NSW EPA  
**The Next Generation (NSW)  
Energy from Waste Facility,  
Eastern Creek EIS**  
Merit Review

Issue | 3 August 2015

Job number 239880-00

A VEHICLE MOVEMENT & TRAFFICE SIGNAGE
1:1500

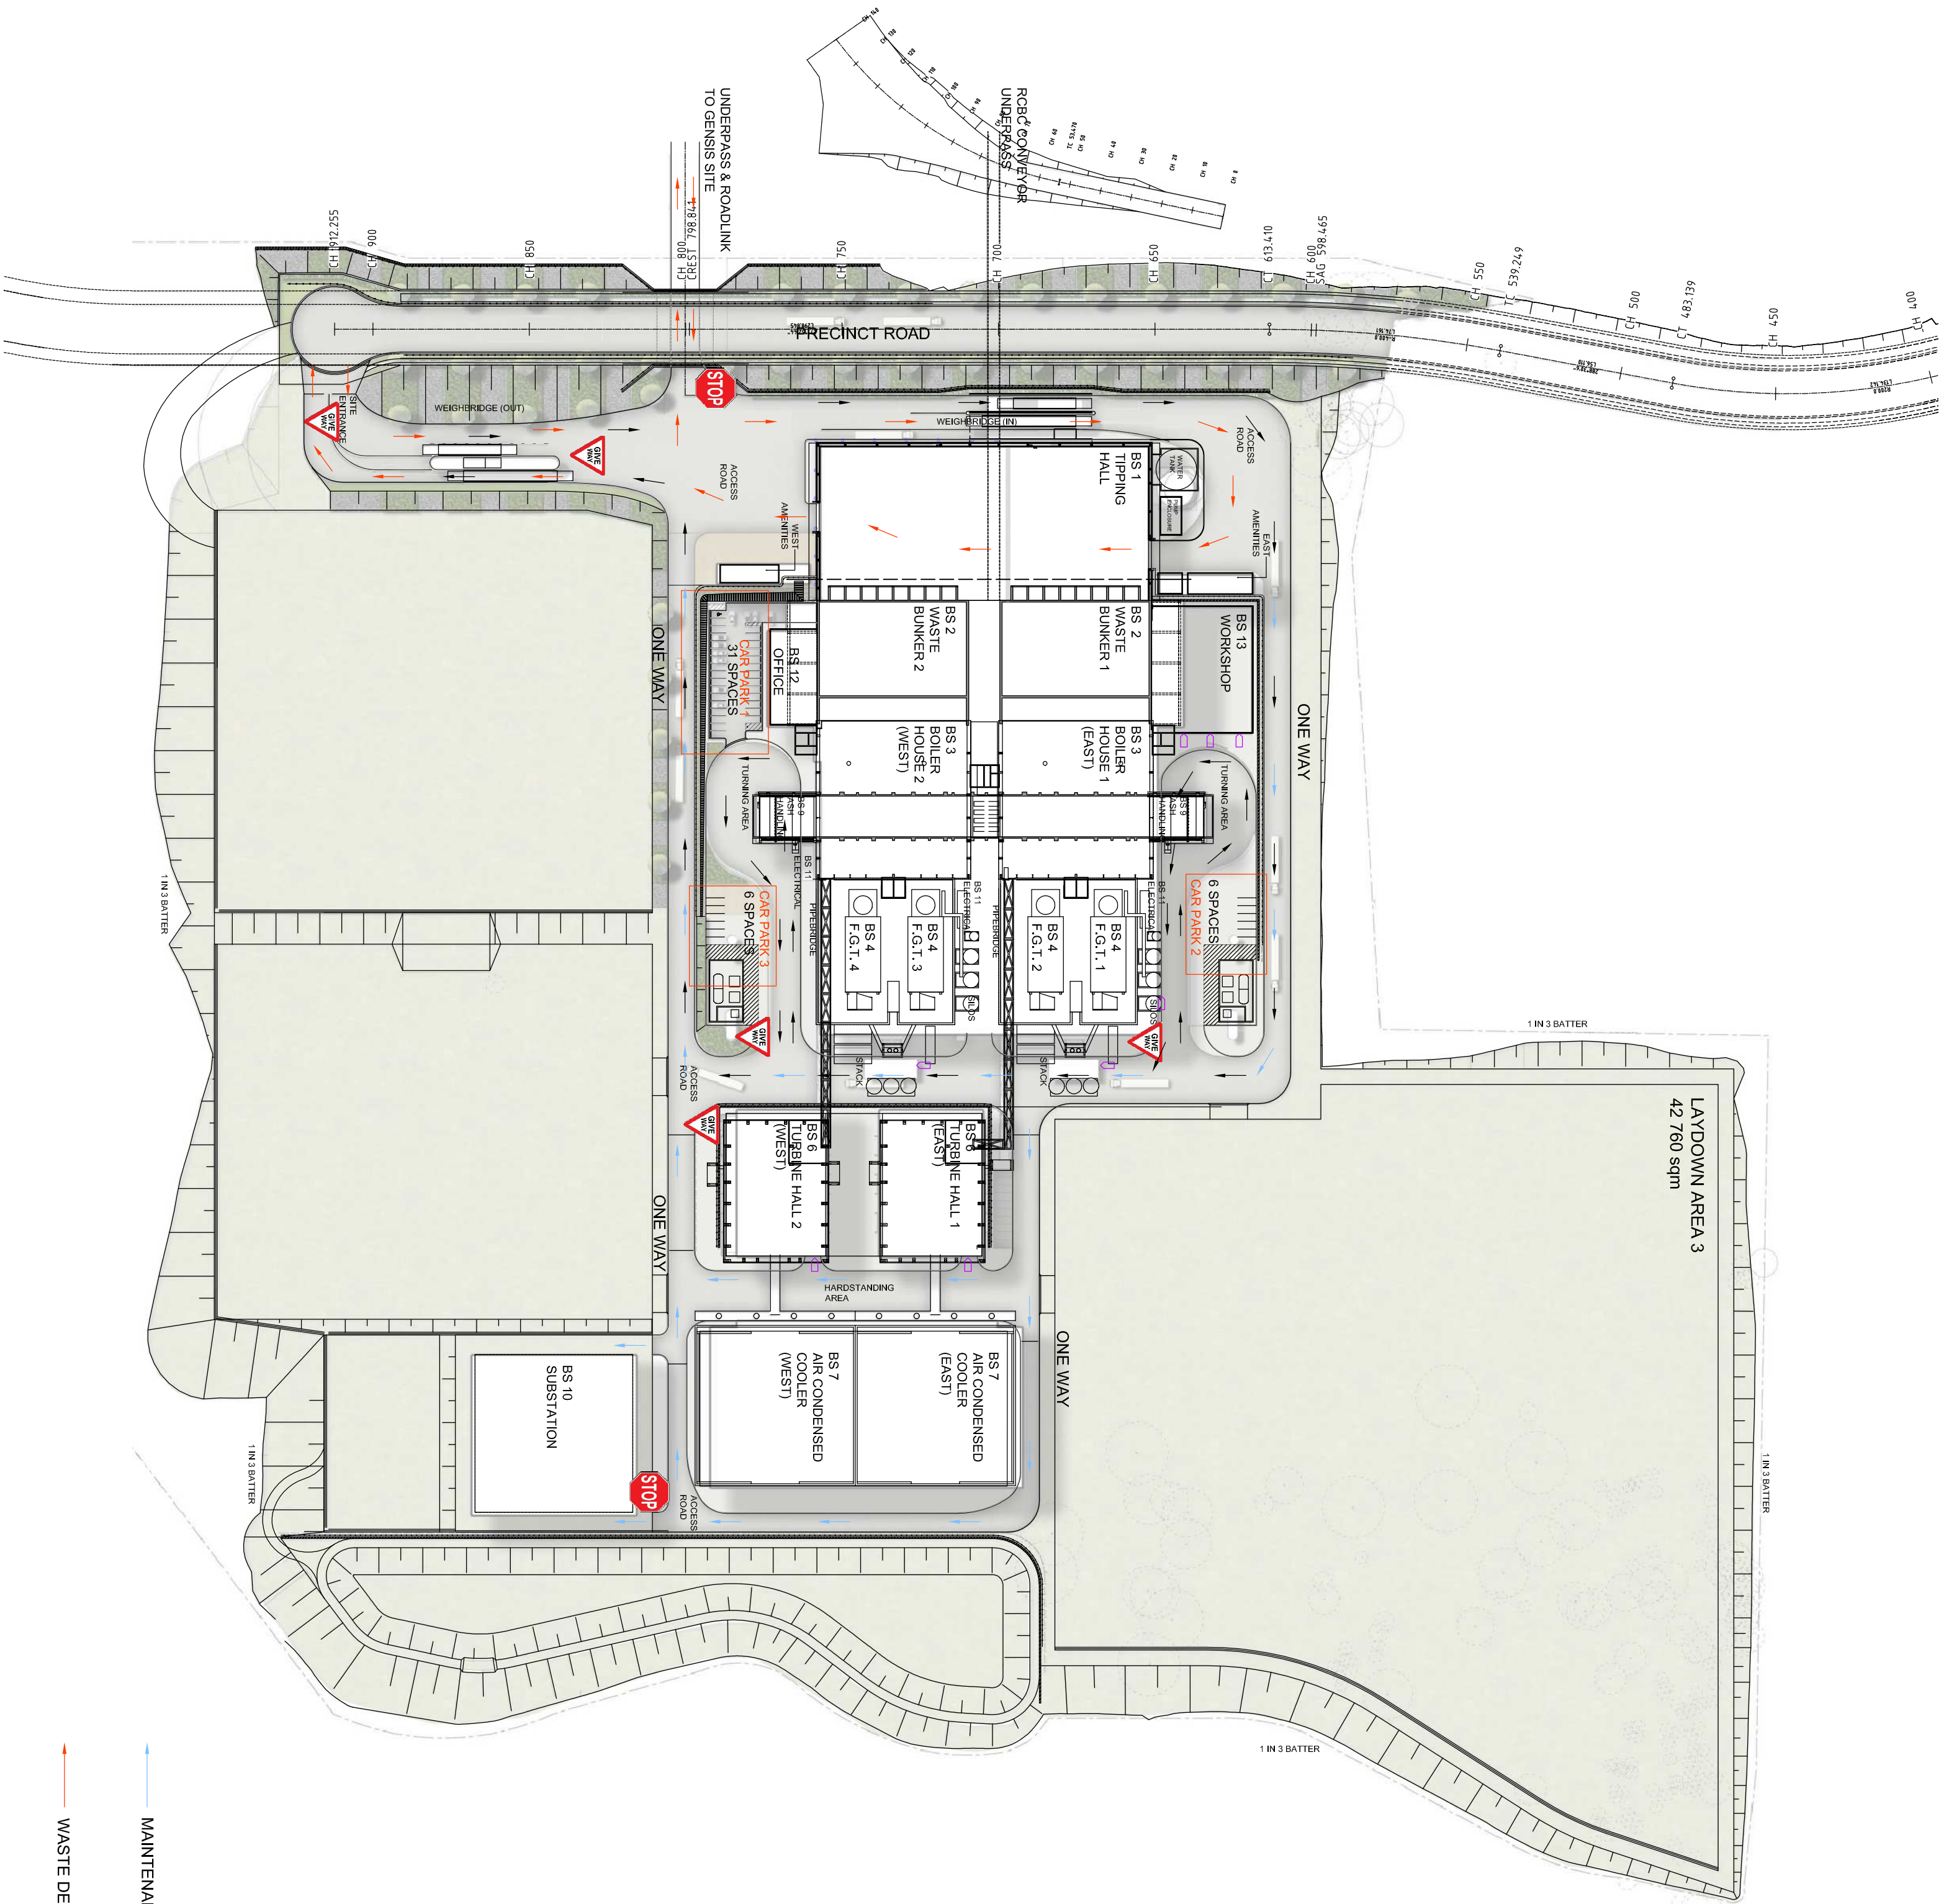
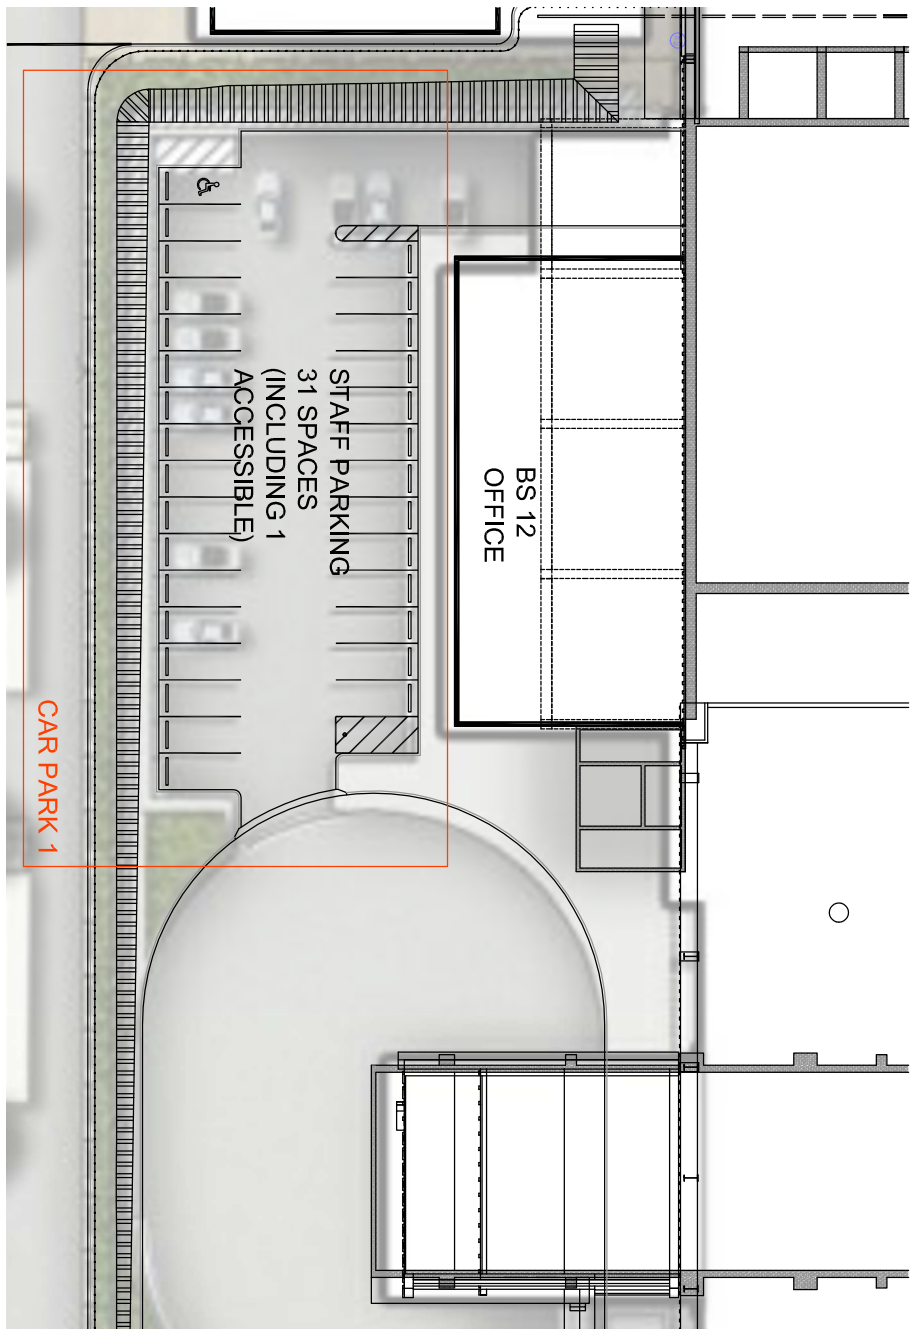
The proposed operational traffic generation on the external road network did not consider or assess the traffic volumes associated with the removal of ash residues from the facility. The EIS states that residual bottom, boiler and APC residues will be removed from site for recovery or disposal. The Fichtner report states in Section 5.8 that the average payload for bottom ash will be 18 tonnes and for APC residues will be 22 tonnes. Although the ash generation rates are unclear (refer Section 3.5) based on the figures quoted in the EIS and Waste Management Report there will be c15,000 one way vehicle movements a year associated with bottom ash removal, and 3,333 on way vehicle movements a year associated with boiler ash and APC residue removal.

It is therefore recommended that the TIA is revised to consider the impact of vehicle movements carrying ash residues and the possible different scenarios for final ash treatment is considered in this assessment (on site recovery, off site recovery, onsite disposal, offsite disposal).
